Ribble Valley Borough Council  
Council Offices  
Church Walk,  
Clitheroe  
Lancashire  
BB7 2RA

Phone: 0300 123 6780  
Email: [developeras@lancashire.gov.uk](mailto:developeras@lancashire.gov.uk)  
Your ref: 3/2025/0537  
Our ref: 3/2025/0537/HDC/KW  
Date: 06 August 2025

**Location:** Root Farm Dunsop Bridge Clitheroe BB7 3BB  
**Proposal:** Change of use of remaining two traditional buildings at Root Farm to Class E use.  
**Grid Ref:** 366014 449950

Client	The Duchy of Lancaster		
Contract	Root Farm Dunsop Bridge		
Drawing title	EXISTING & PROPOSED GROUND FLOOR PLANS		
Scale	Job No.	Drg No.	
1:100	HB105	D/CB	03

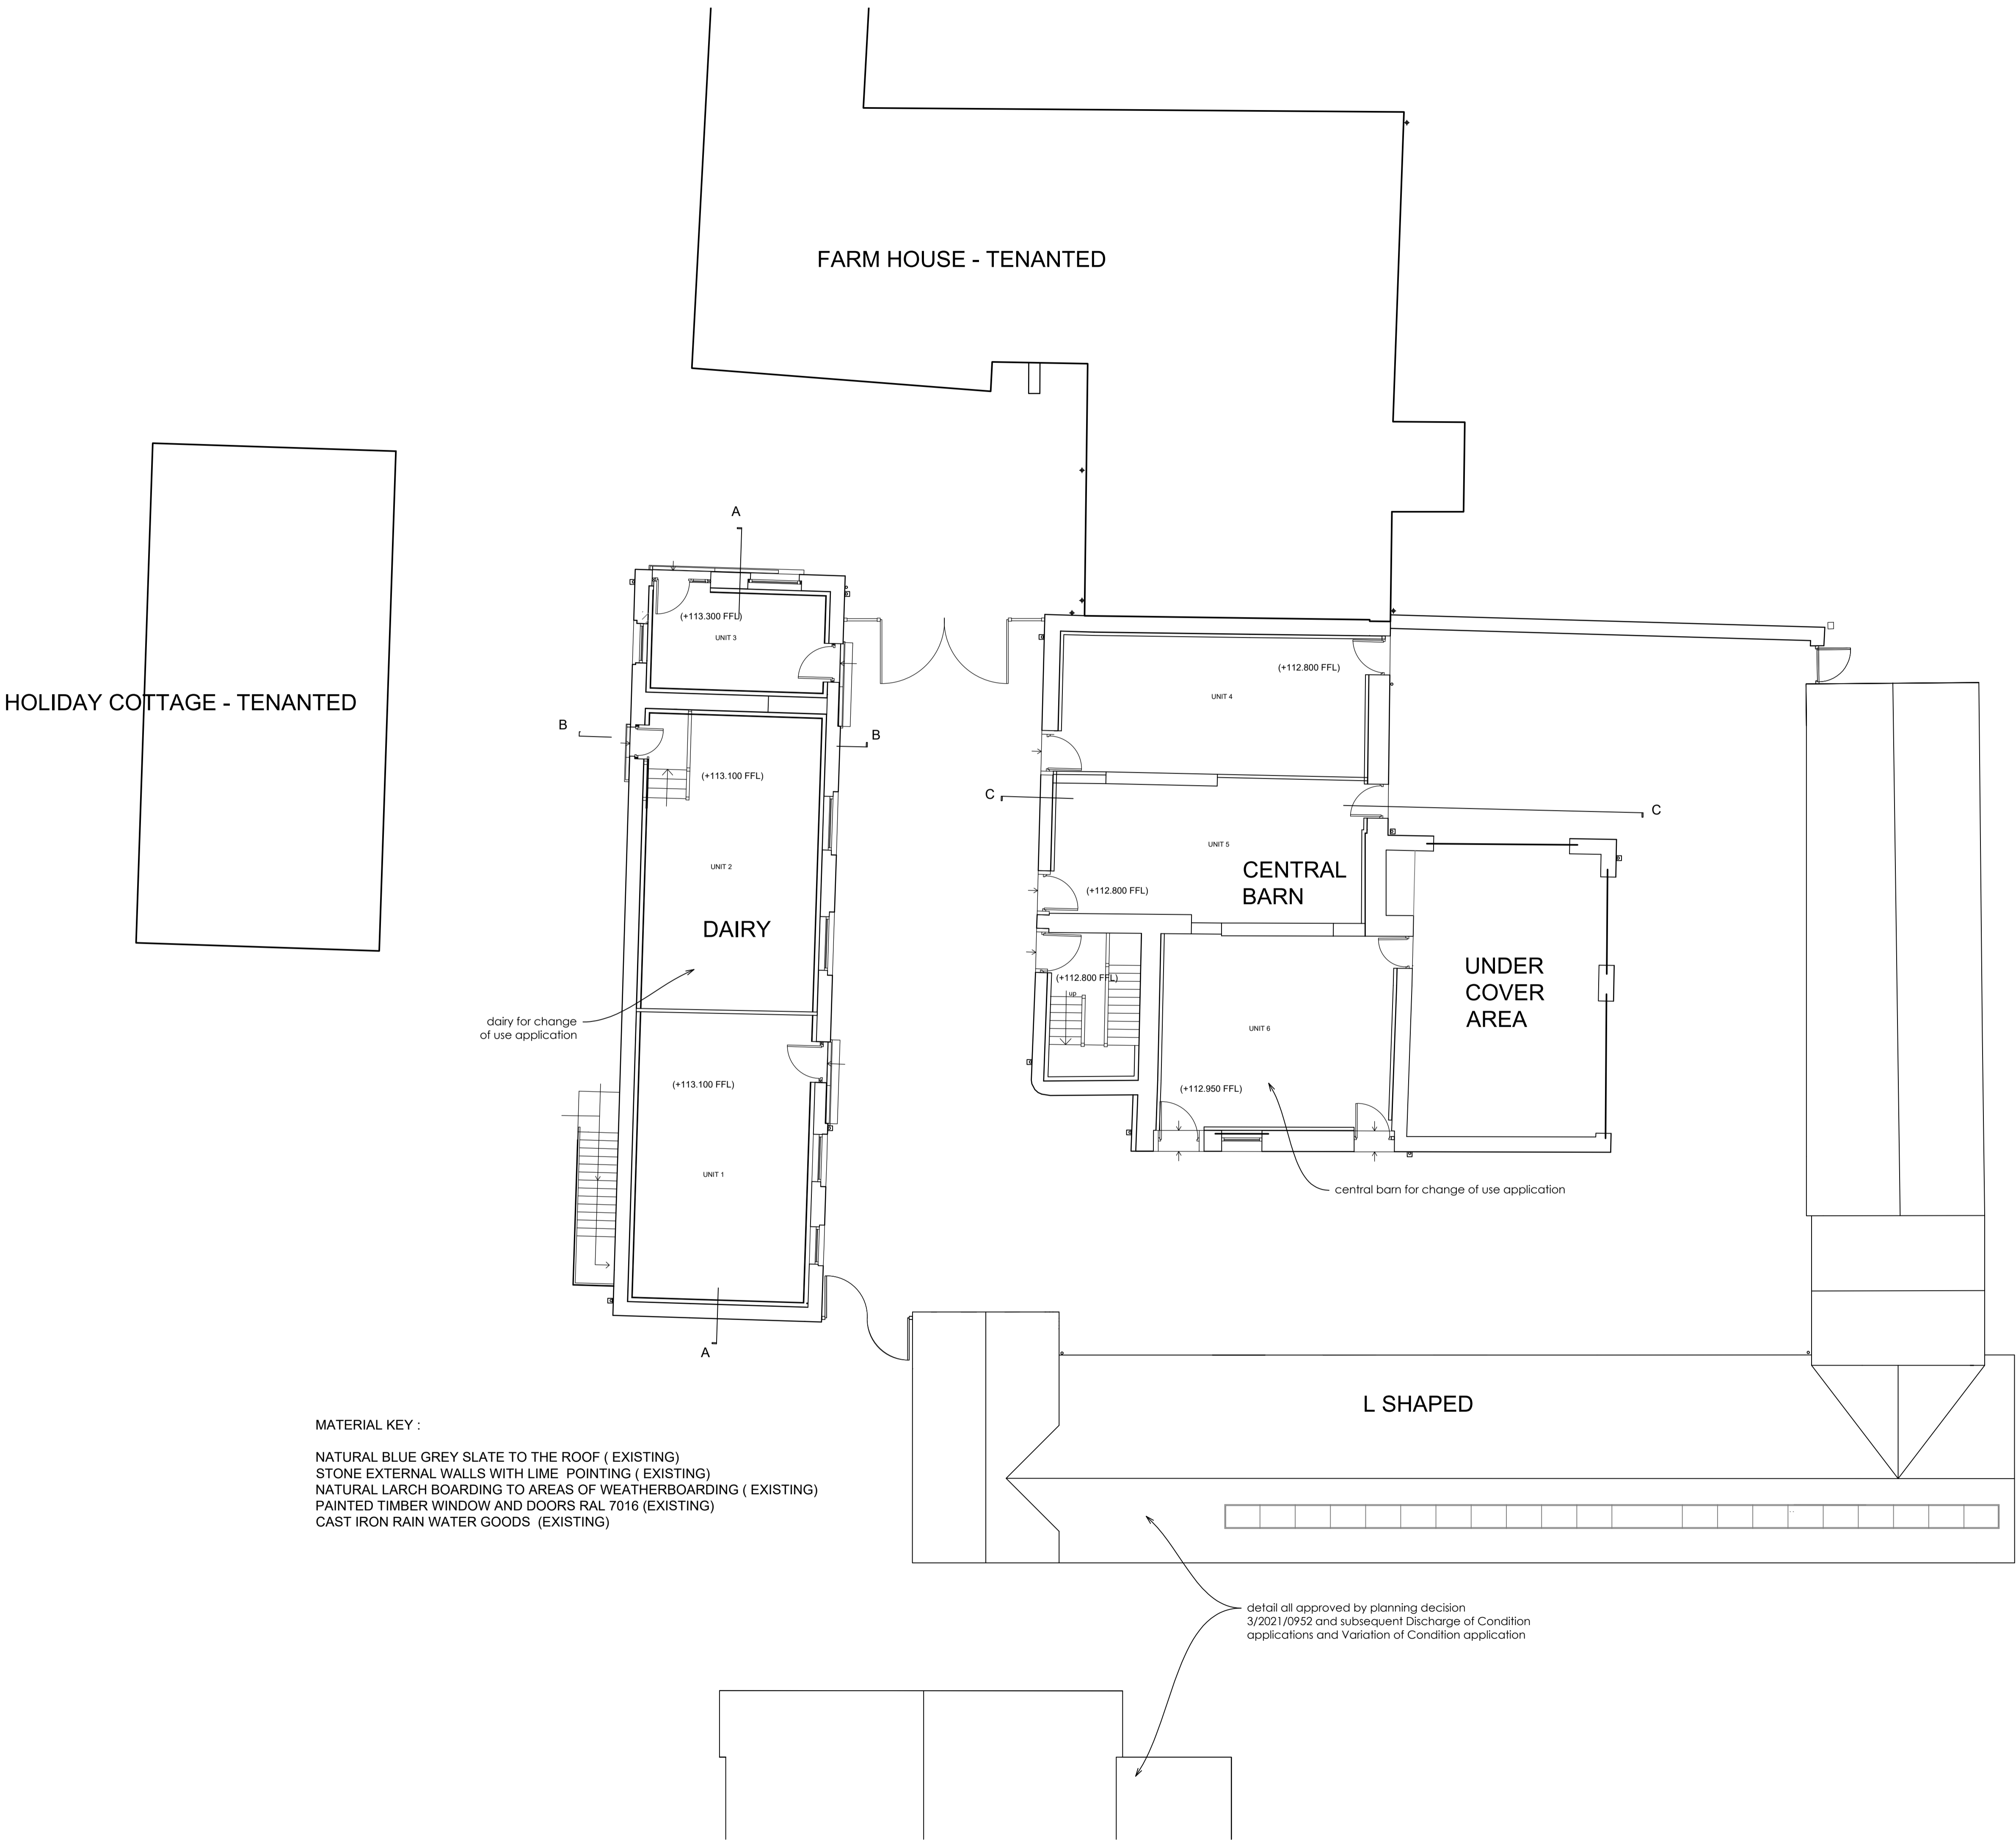
Given the current lack of information, the LHA would look for the site to increase the parking provisions by a total of 20 spaces, which would meet the requirements of expected parking demand when considering the calculations above.

The LHA recently undertook a site visit to aim to understand the current demand within the site and noted that the passing place previously approved is currently being used to support on-site parking provisions, which is not acceptable.
